**Our Case Number:** ABP-317660-23

**Re:** Busconnects Kimmage to city centre core bus corridor scheme  
Kimmage, Dublin

# Observation on a Strategic Infrastructure Development Application

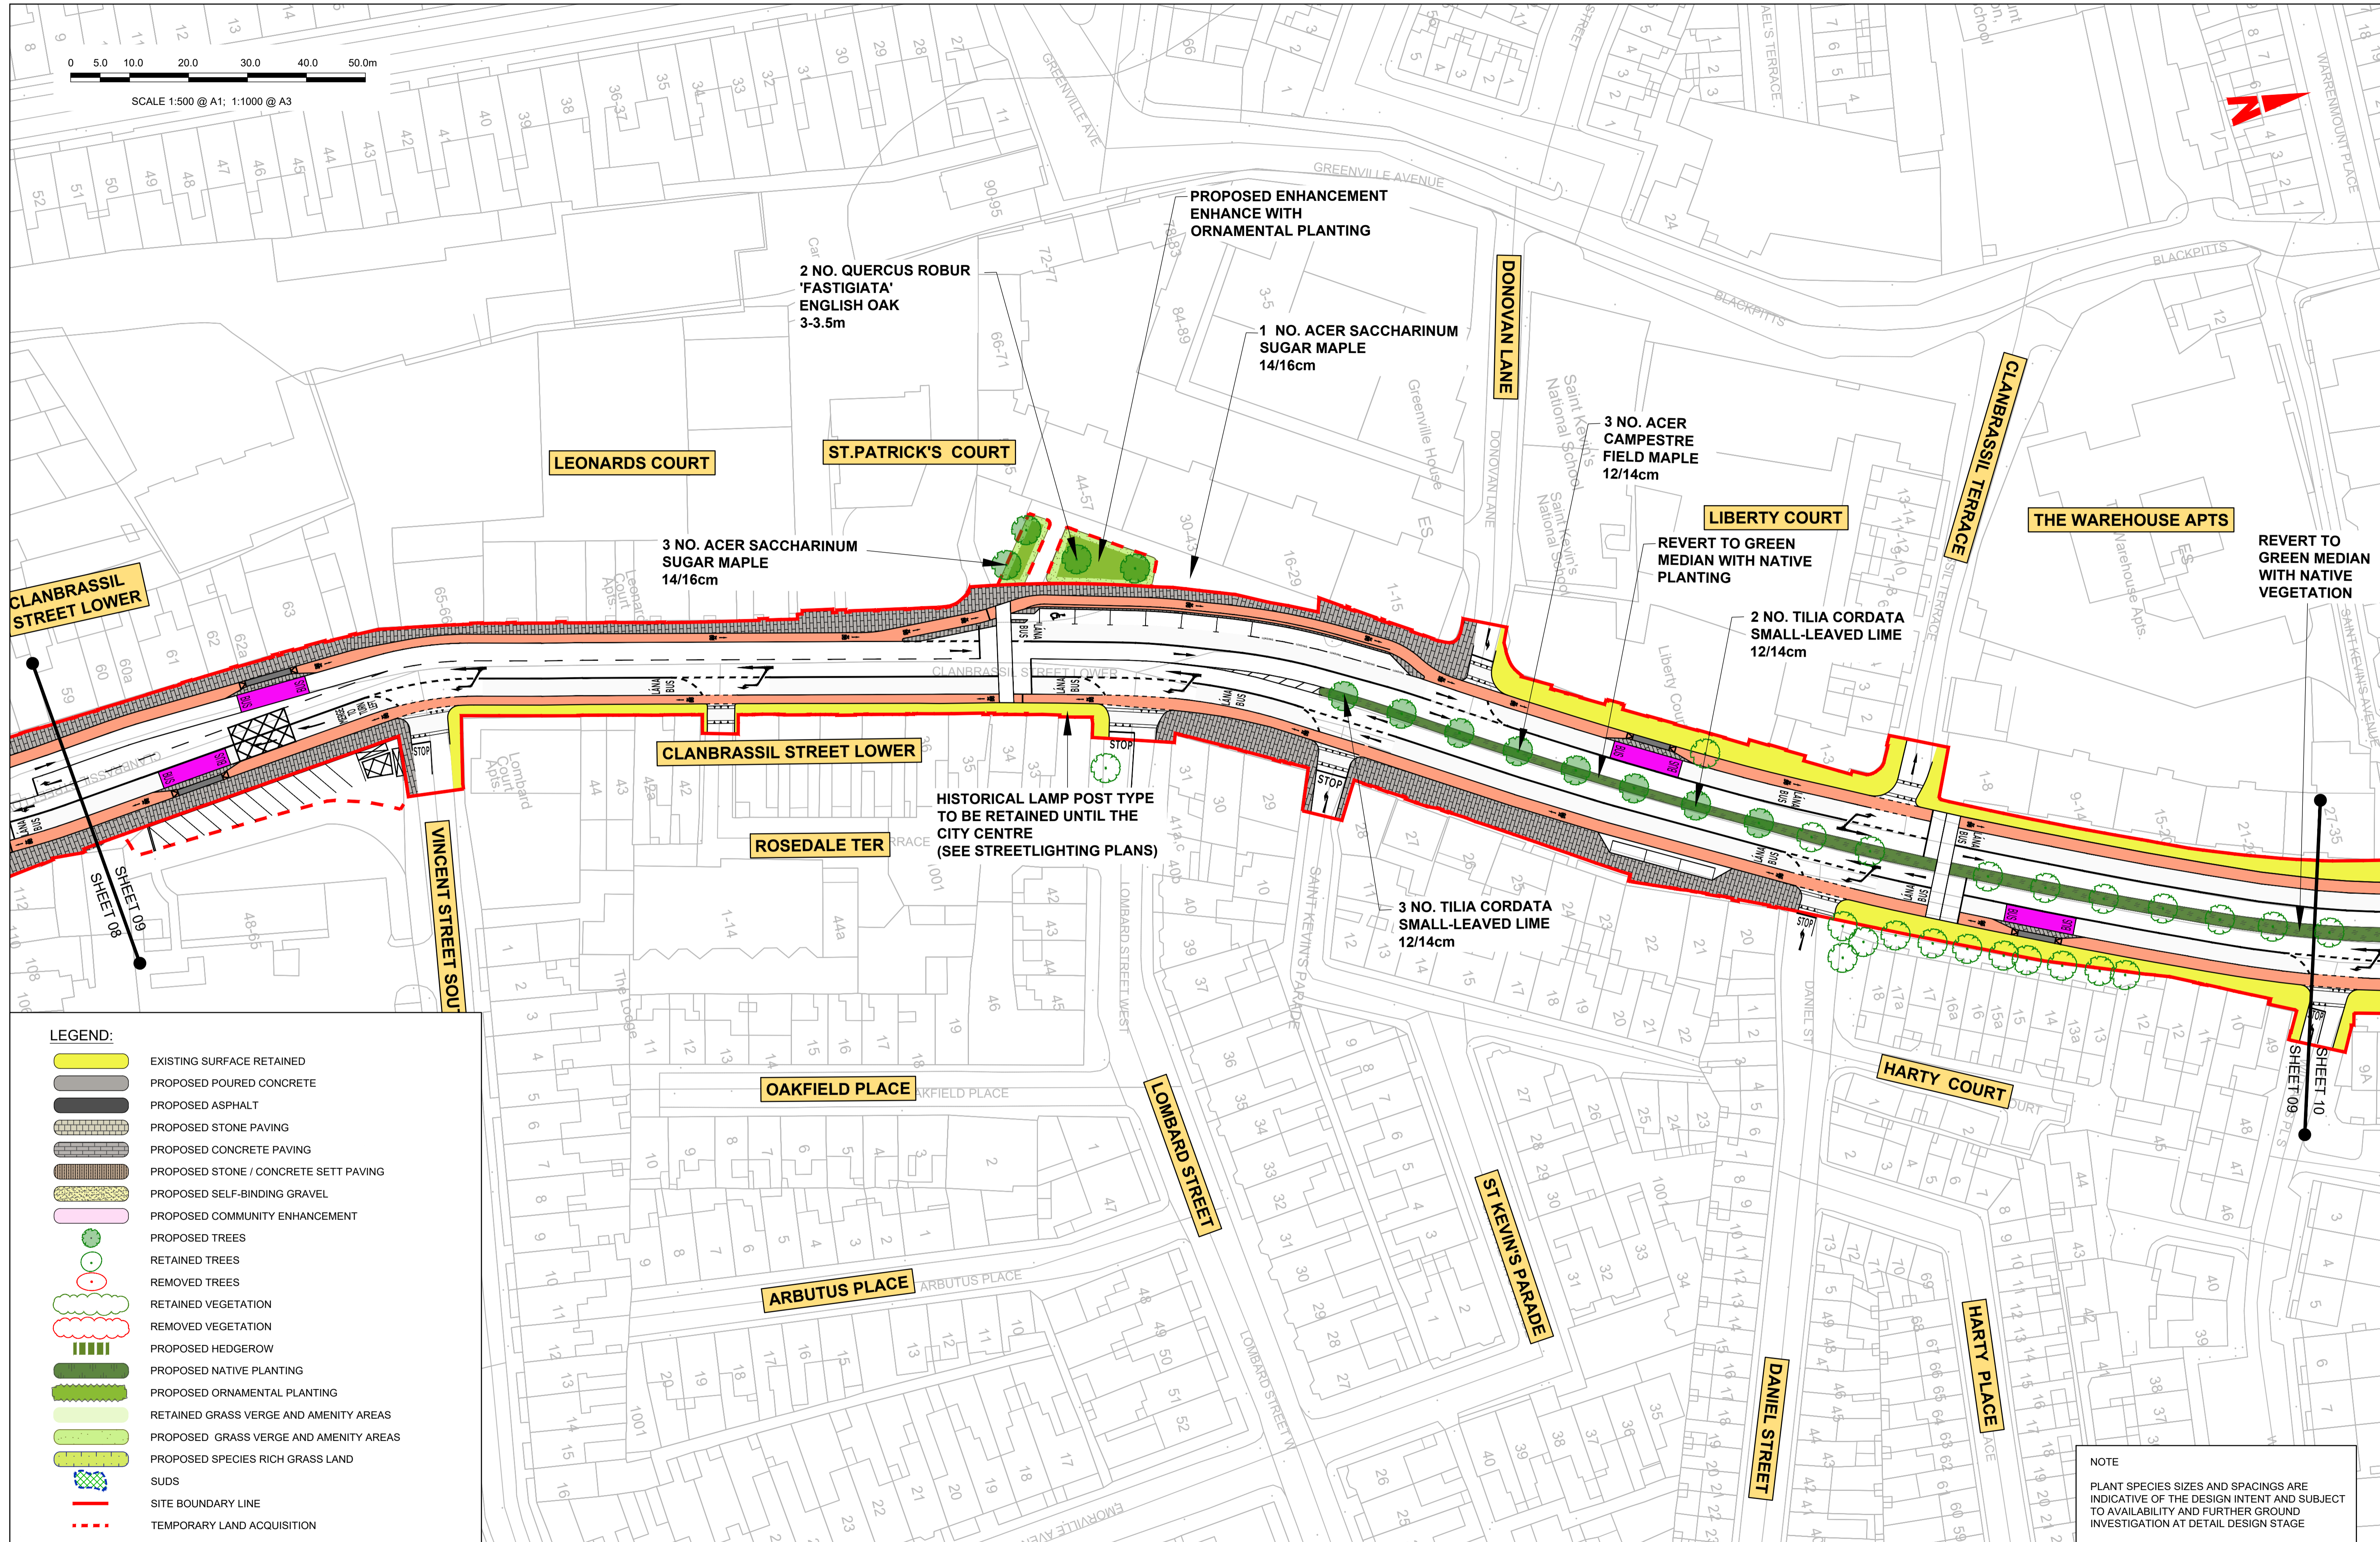
When this all finished it is proposed to plant 4 big trees in the green area beside Patrick's Court and Greenville Place where I have my only two windows of the apartment.

This will block all my light and the sun to the property.

I consider that the proposed trees in the green area will create immediate loss of light amenity and overshadowing my property.
